CITY OF ALBUQUERQUE

March 12, 2018

RE: **Montessori on the Rio Grande Charter School**
1650 Gabaldon Dr NW
Grading and Drainage Plan
Engineer's Stamp Date 3/6/18
Hydrology File: H12D008B

**C102**

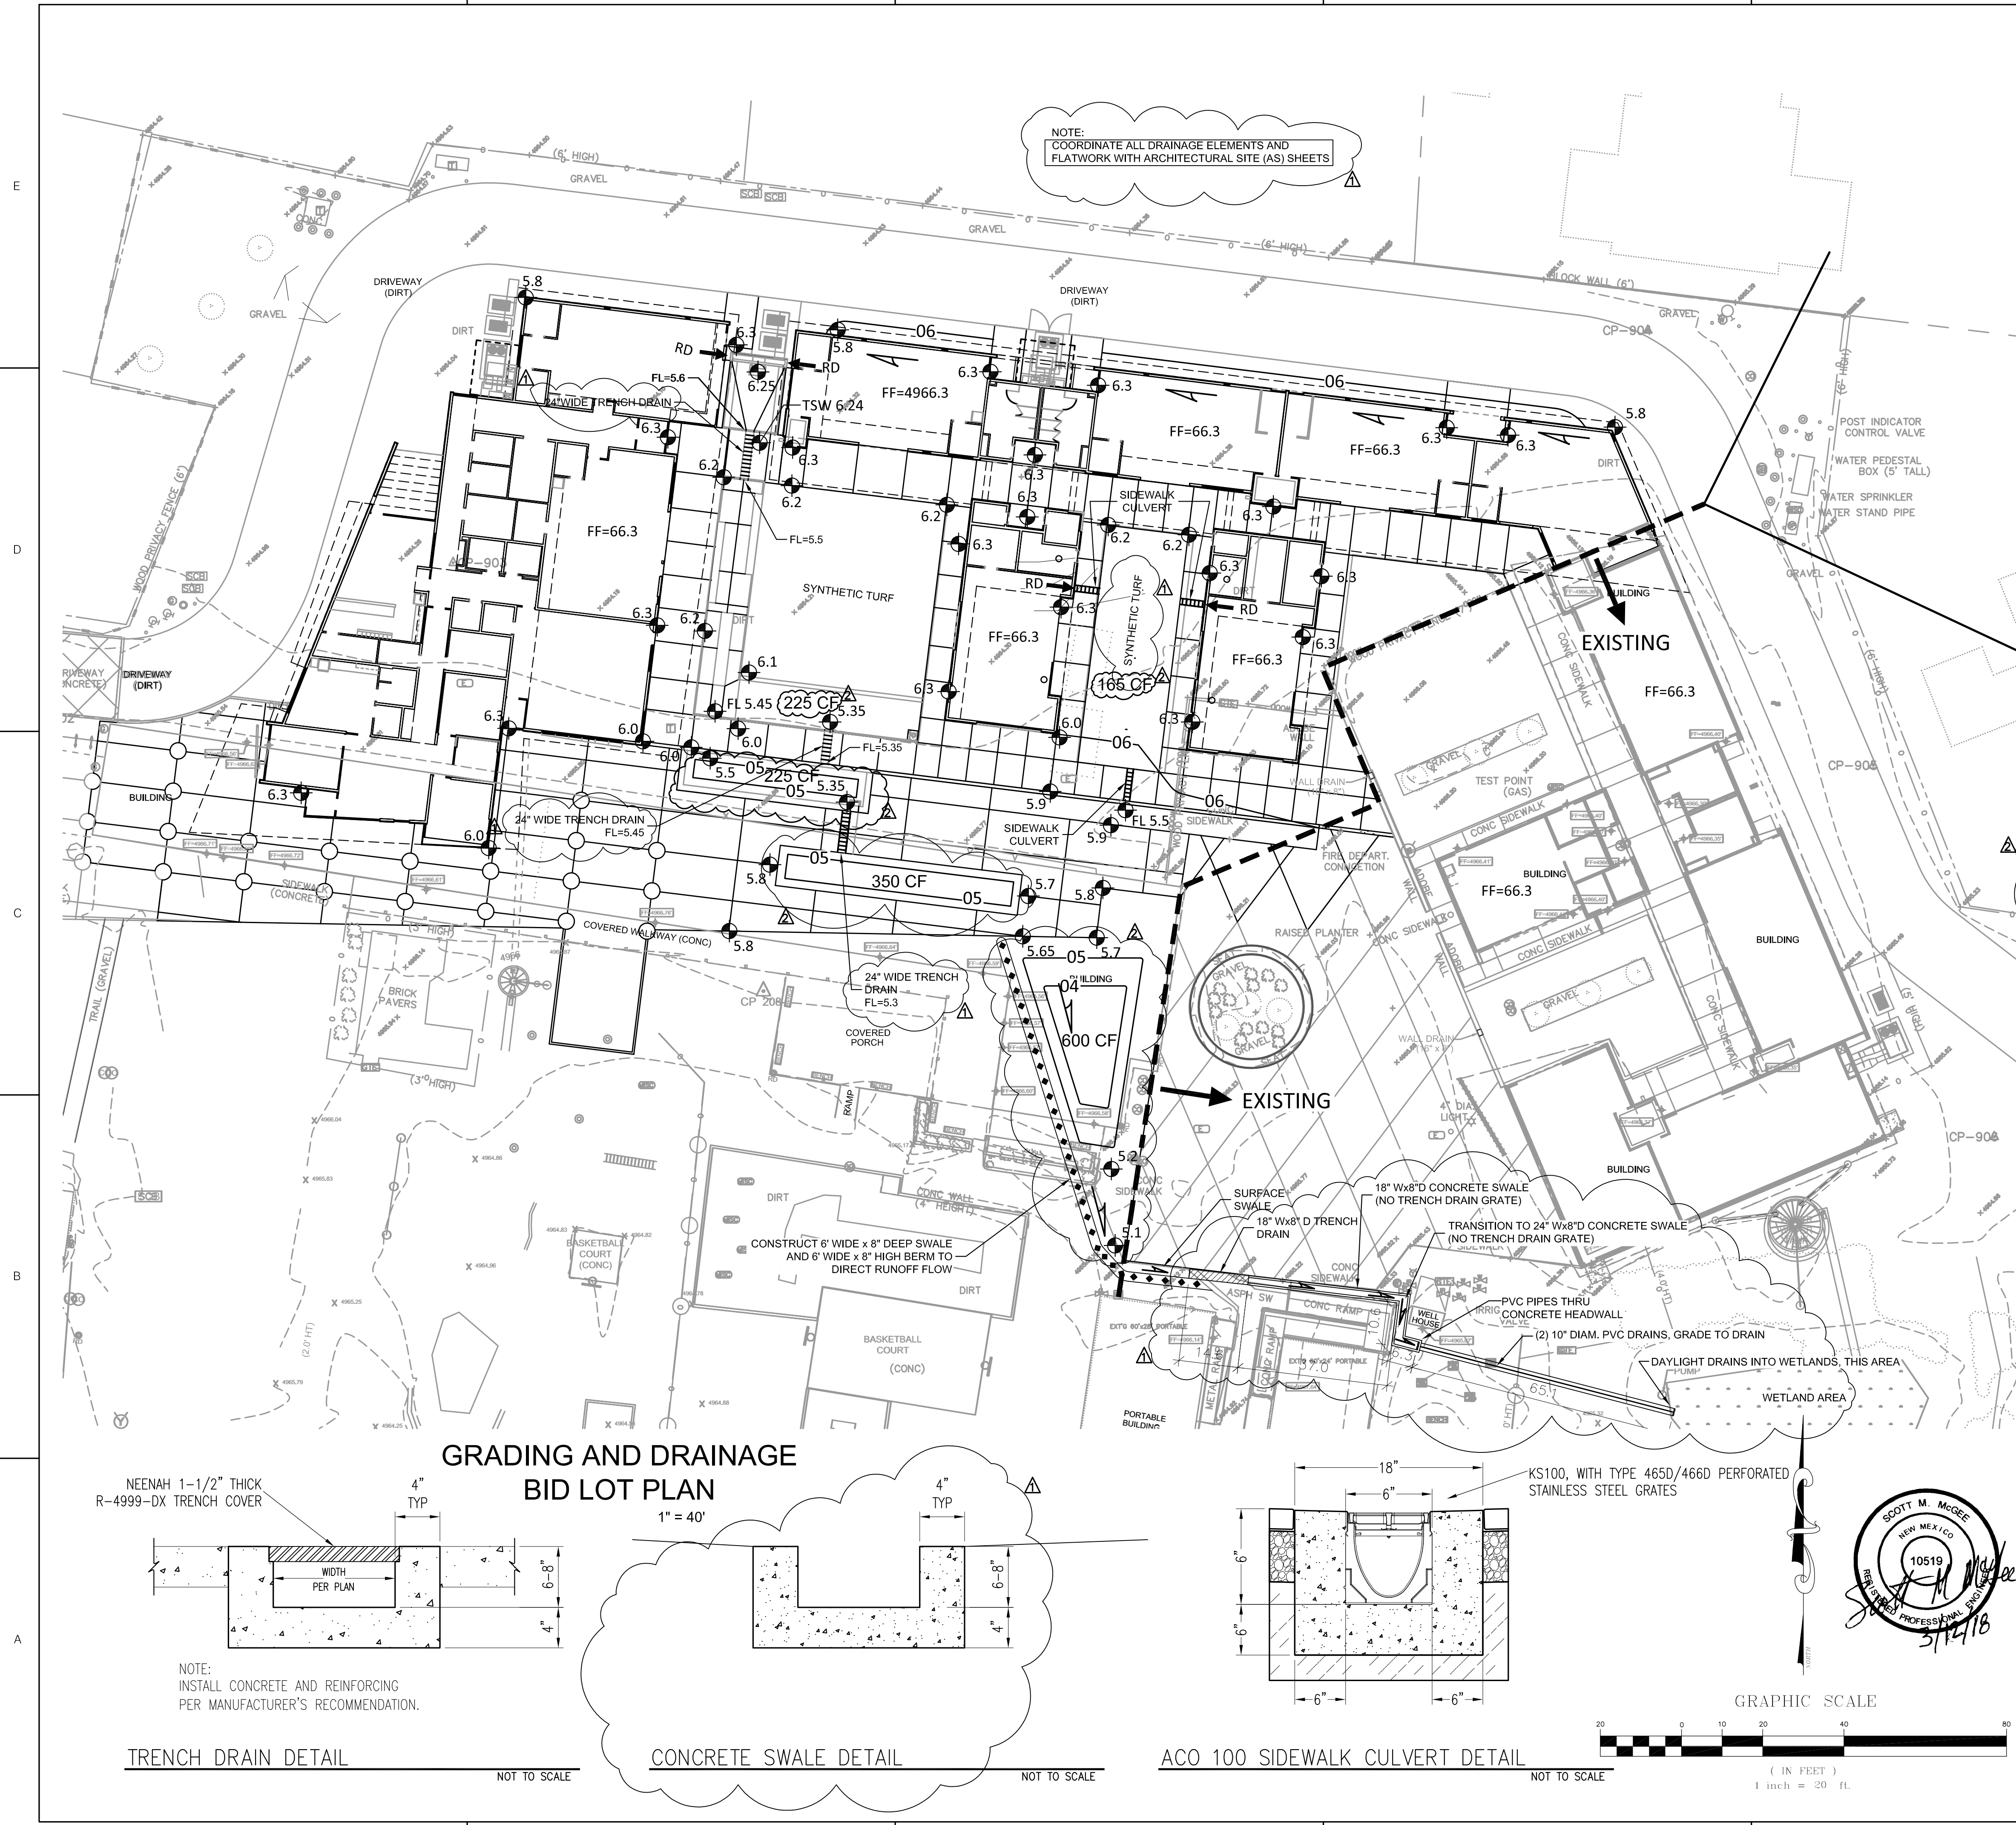
- PO Box 1293
- Albuquerque
- NM 87103
- www.cabq.gov
1. Onsite retention of the increased runoff needs to be substantiated. The increase appears to be ~2200CF (100-yr, 10day volume increase), yet only 1200CF of new storage is provided.
 - o If the existing wetland has additional storage capacity, please provide the supporting pond volumes and hydrology for it.
 - o If pond routing is being used to shave the peak flow, please provide that analysis.
 2. A Private Facility Drainage Covenant is required for the stormwater ponds. The original notarized form, exhibit A (legible on 8.5x11 paper), and recording fee (\$25, payable to City of Albuquerque) must be turned into DRC (4th, Plaza del Sol) for routing. Please contact Charlotte LaBadie (clabadie@cabq.gov, 924-3996) or Madeline Carruthers (mtafoya@cabq.gov, 924-3997) regarding the routing and recording process for covenants.
